# Mallard Pass

### Environmental Statement Volume 2 Appendix 2.3: Scoping Opinion Response Matrix

PINS Ref: EN010127

## **Appendix 2.3: EIA Scoping Opinion Response**

Location, Order Limits and Grid Coordinates Plans

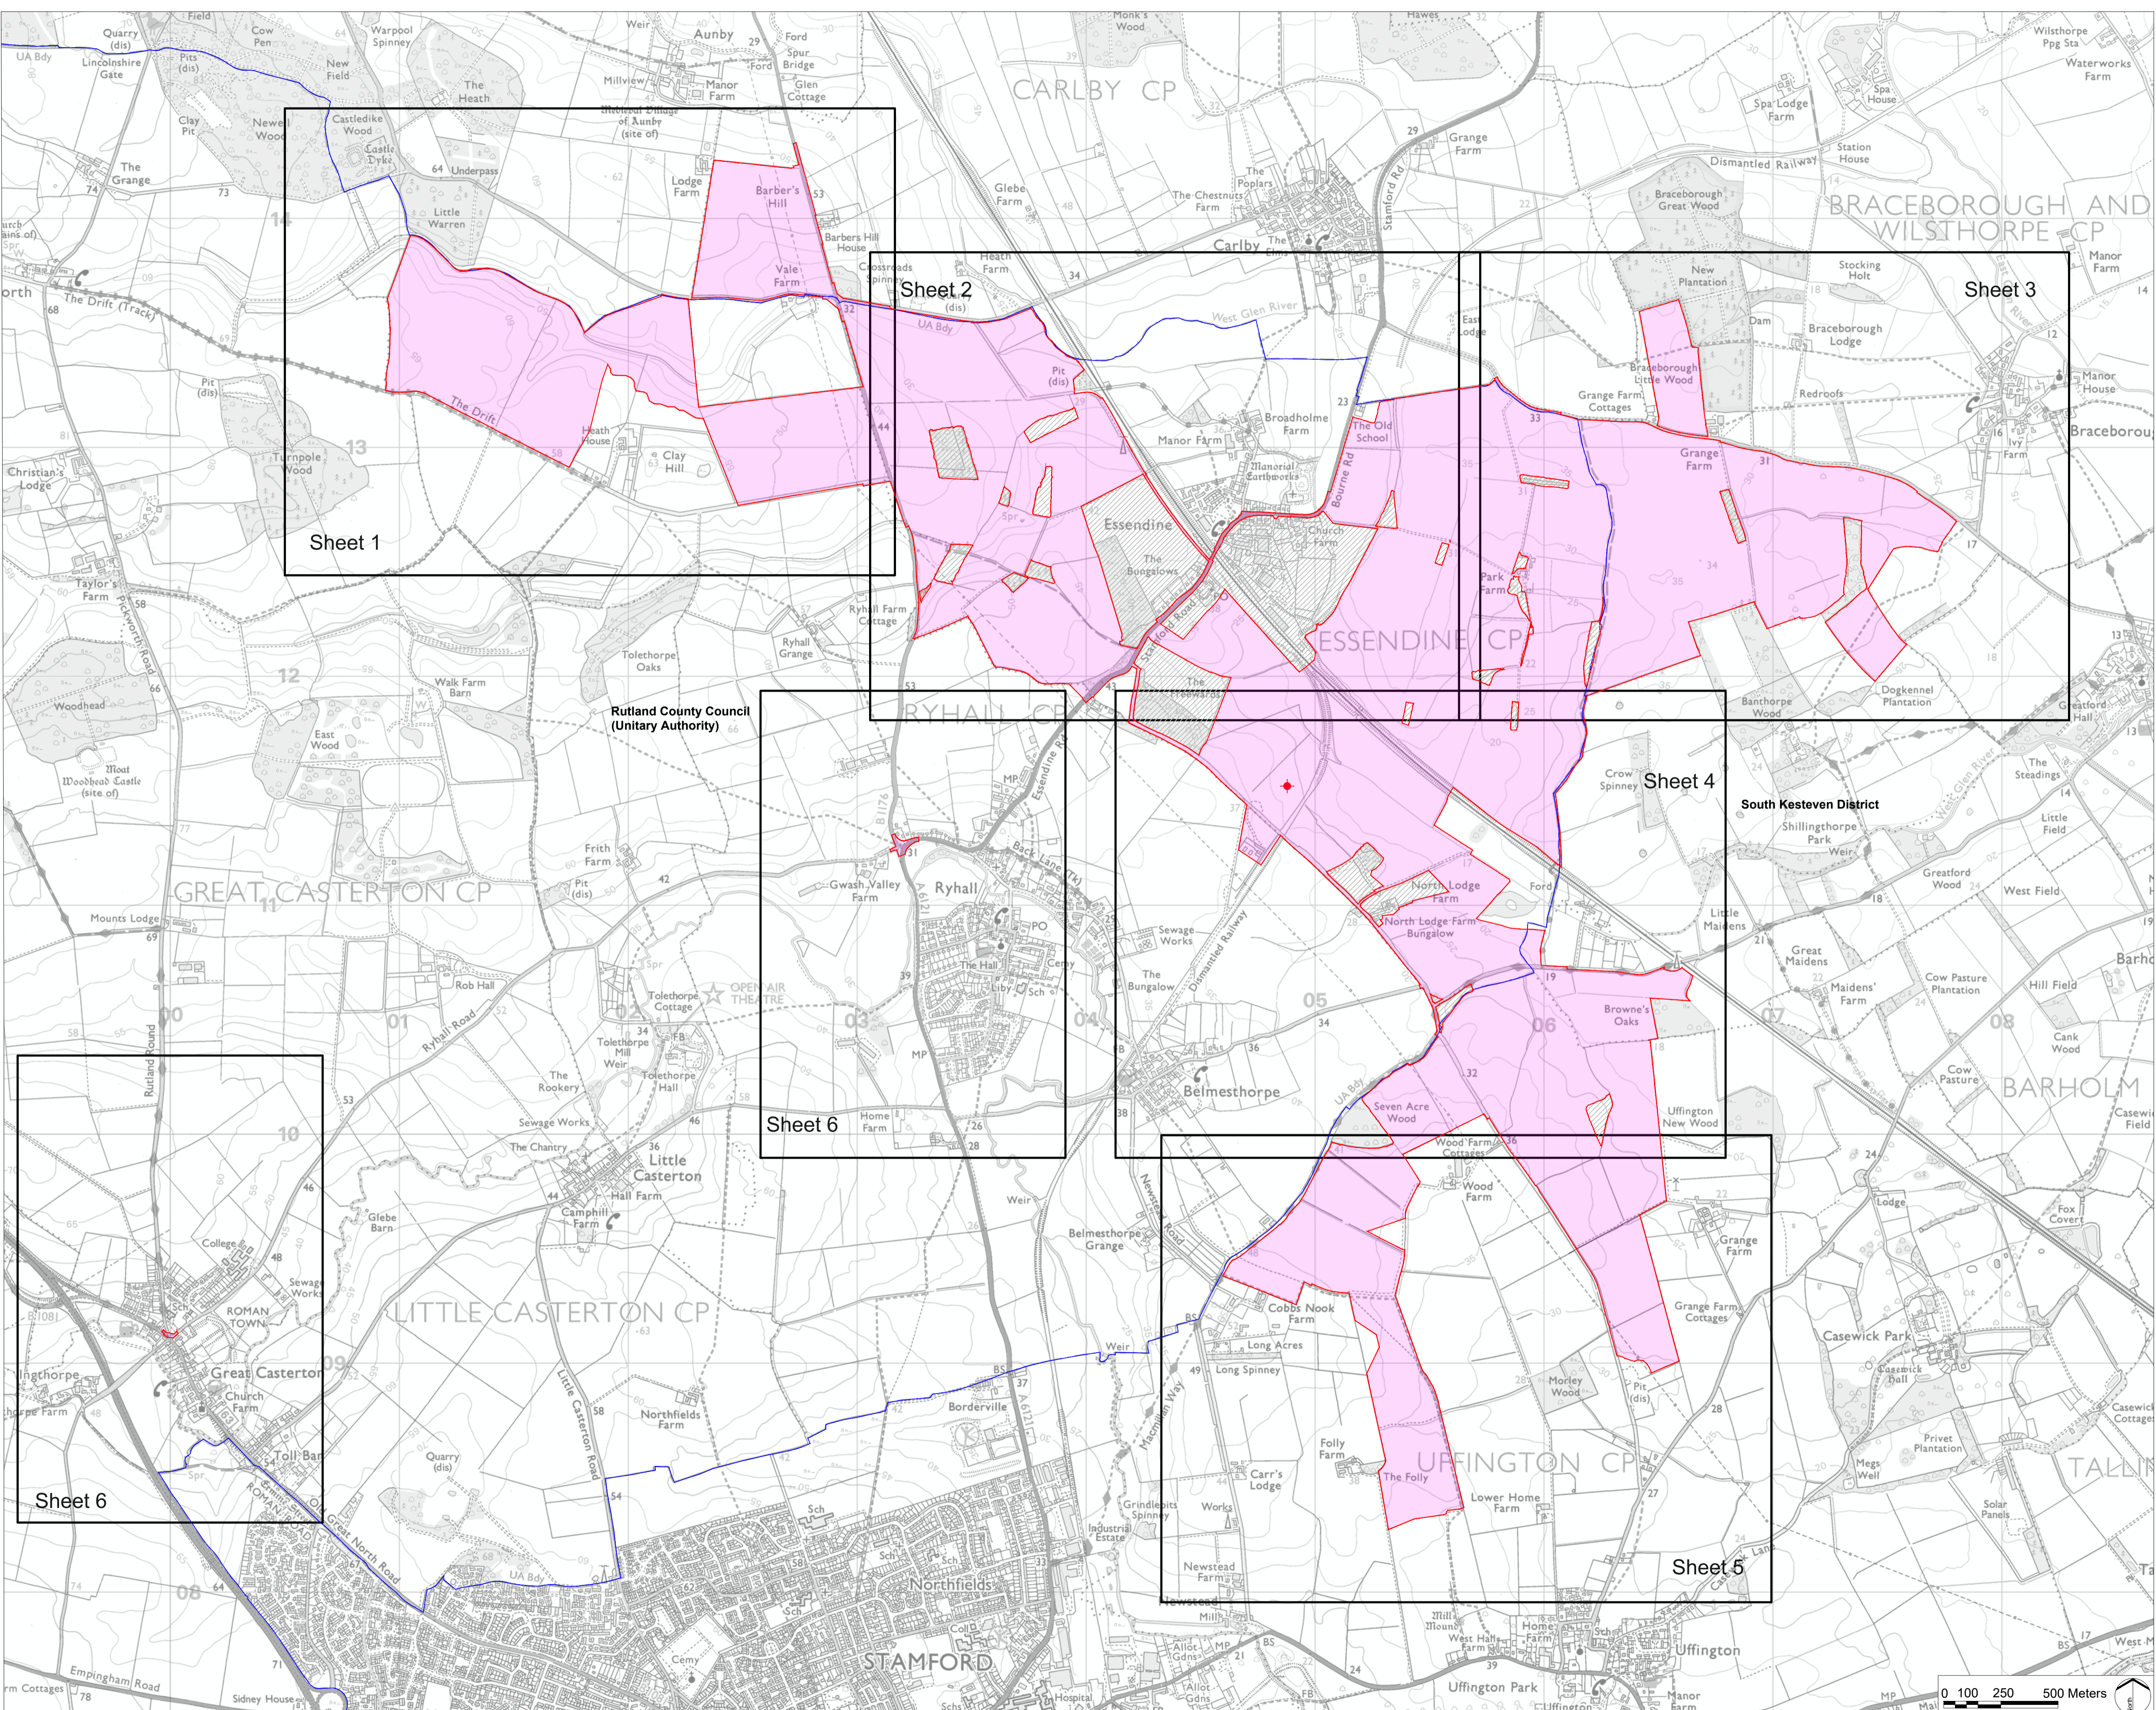
2.1.1	Figure 2.3	Topography	The topographical plan included in the Scoping Report lacks clarity regarding the land that is included in the redline boundary. It appears that certain field areas have been excluded from the red line boundary. The ES needs to include plans which clearly show the land required for the Proposed Development.	ES Figure 6.1 [EN010127/APP/6.3] presents the topography across the Site.  Figure 3.1 includes a hatch to identify which areas are excluded from the Site.  The Location, Order Limits and Grid Coordinates Plan [EN010127/APP/6.3] show the extent of the Order Limits.
